El Paso County
STORMWATER MANAGEMENT PLAN

Falcon Storage Subdivision

County Project No.: PPR2232

December 12-2022

TEMPORARY SEDIMENTATION BASIN (TSB)

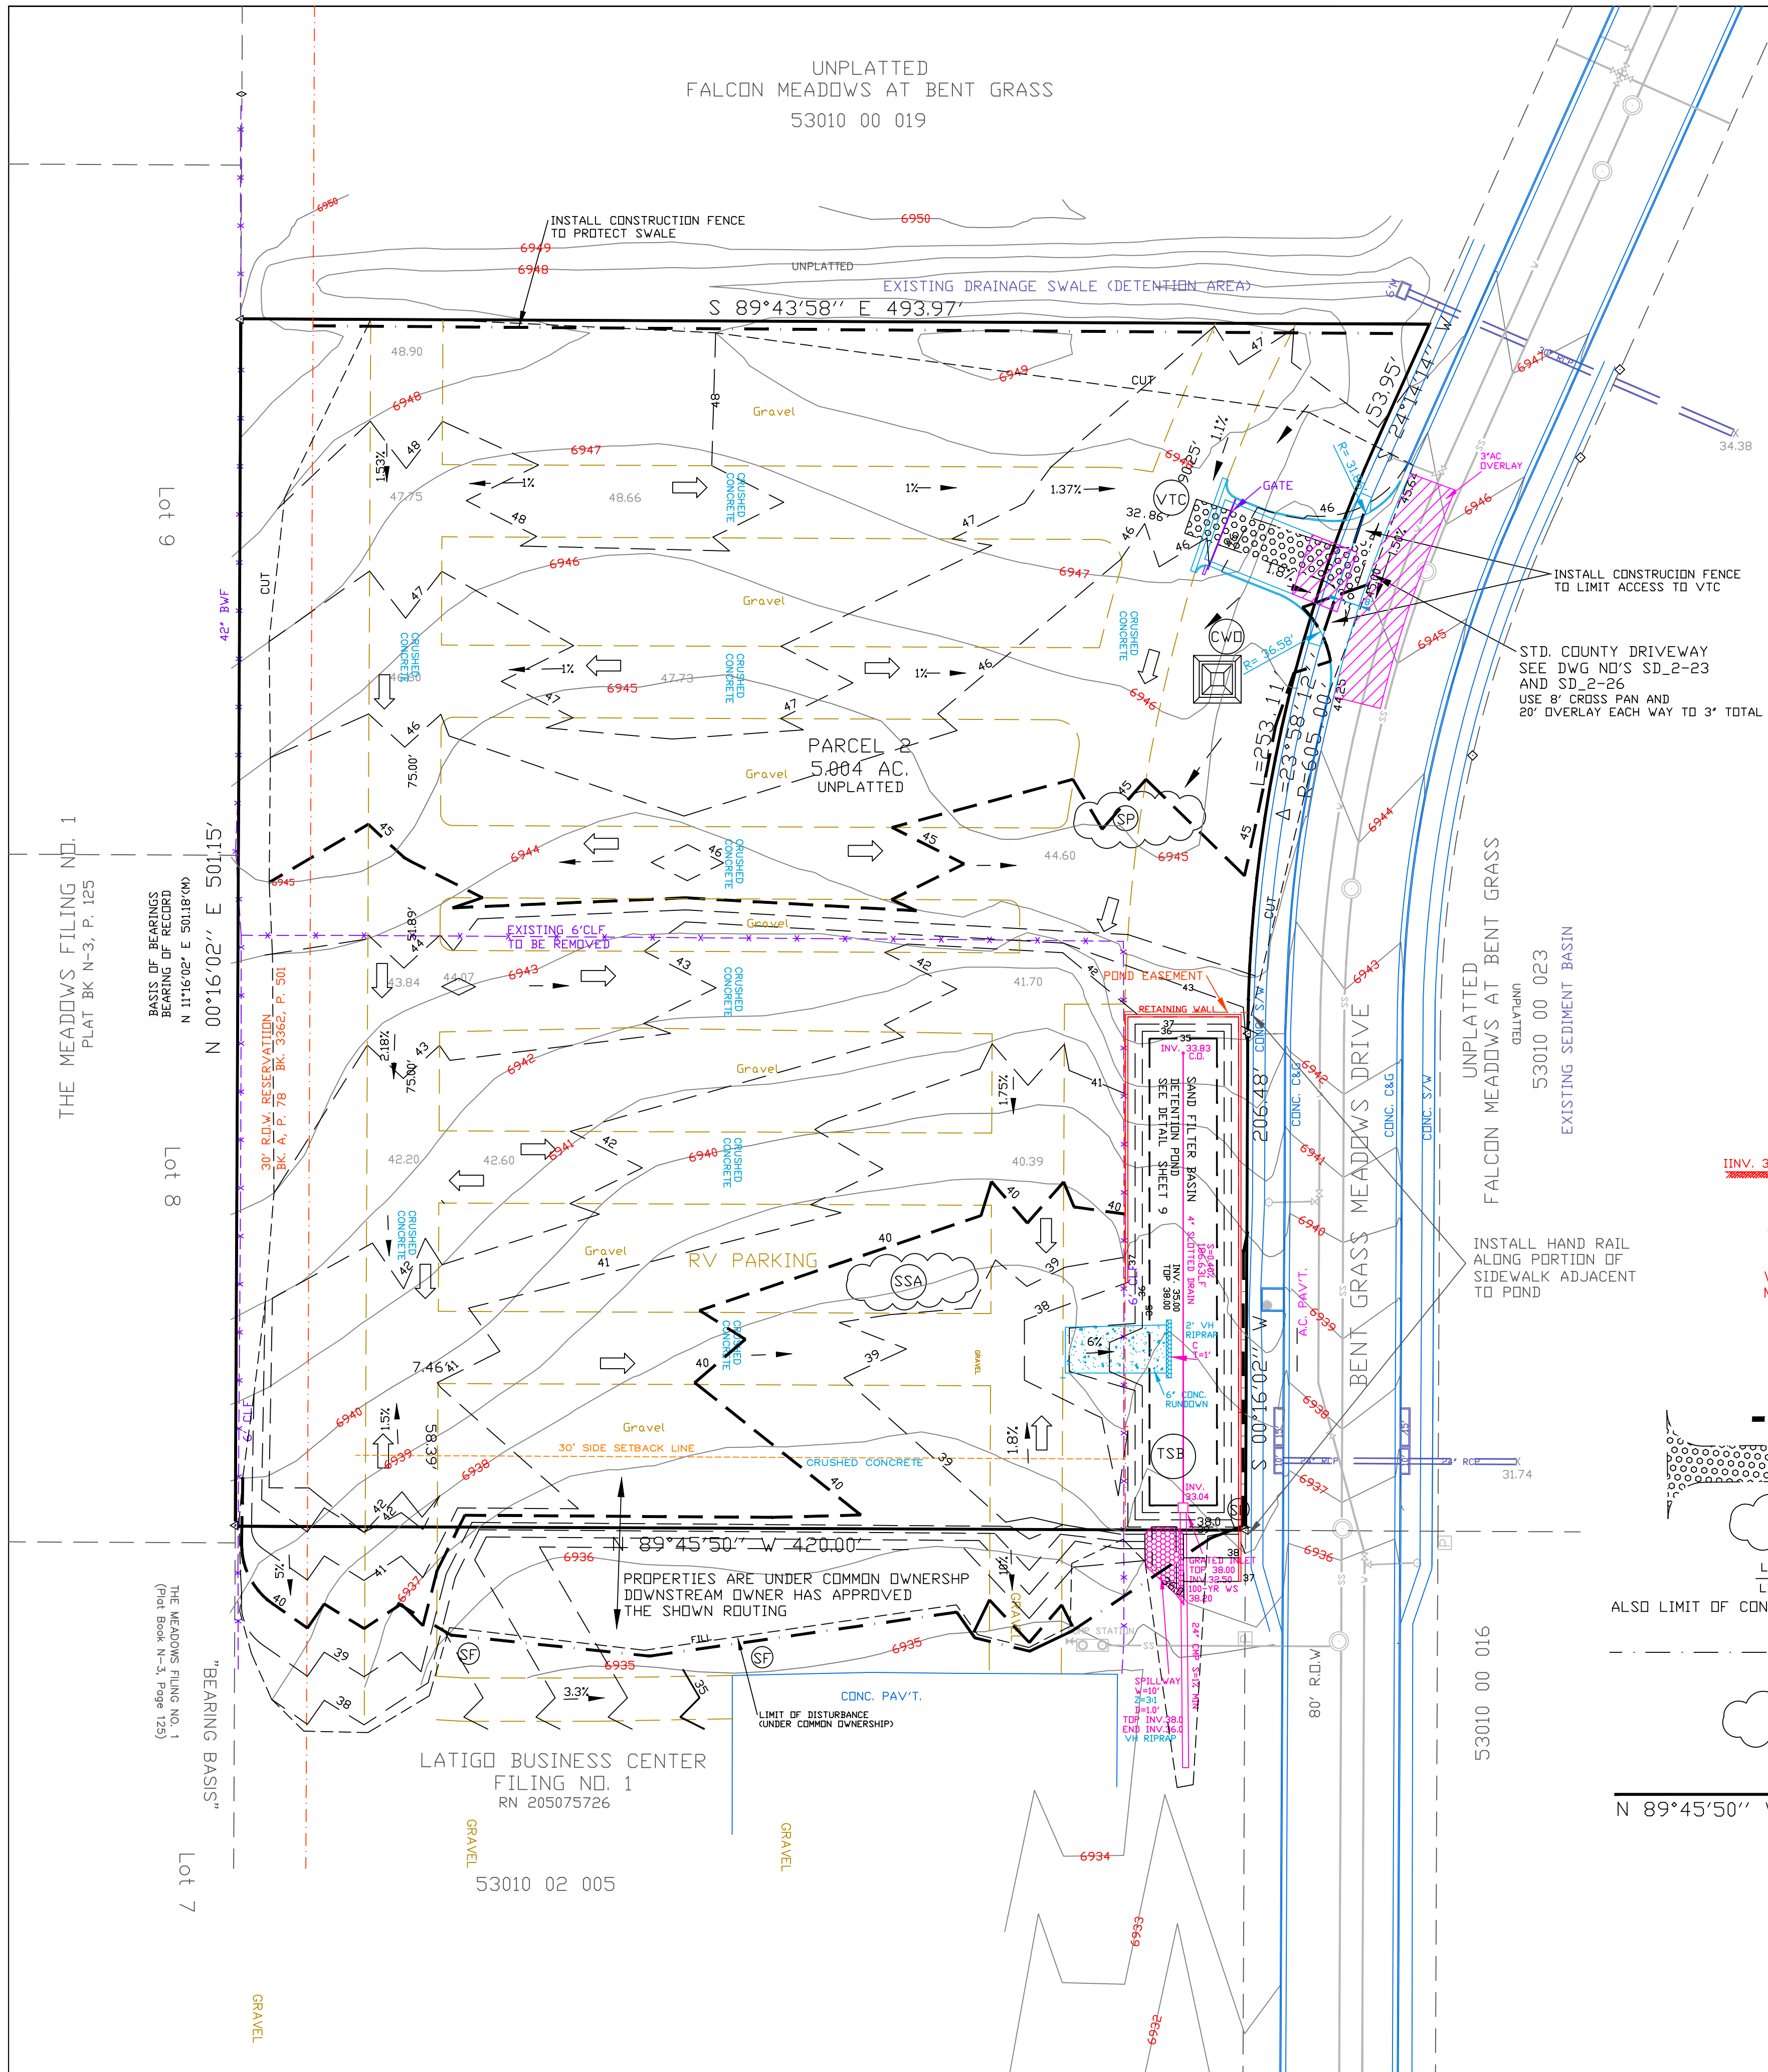
1) Structural practices: As indicated on the enclosed Grading and Erosion Control Plans, erosion will be contained through the use of said silt fencing or in the case of the project exit an VTC (vehicle tracing control pad). See Plans for locations and details on silt fencing and VTC. The portion of the lot that has experienced grading will be landscaped or reseeded per County Code (see DCM Volume II for details). discuss TSB. unresolved.

discuss TSB inspection and maintenance.
Unresolved.
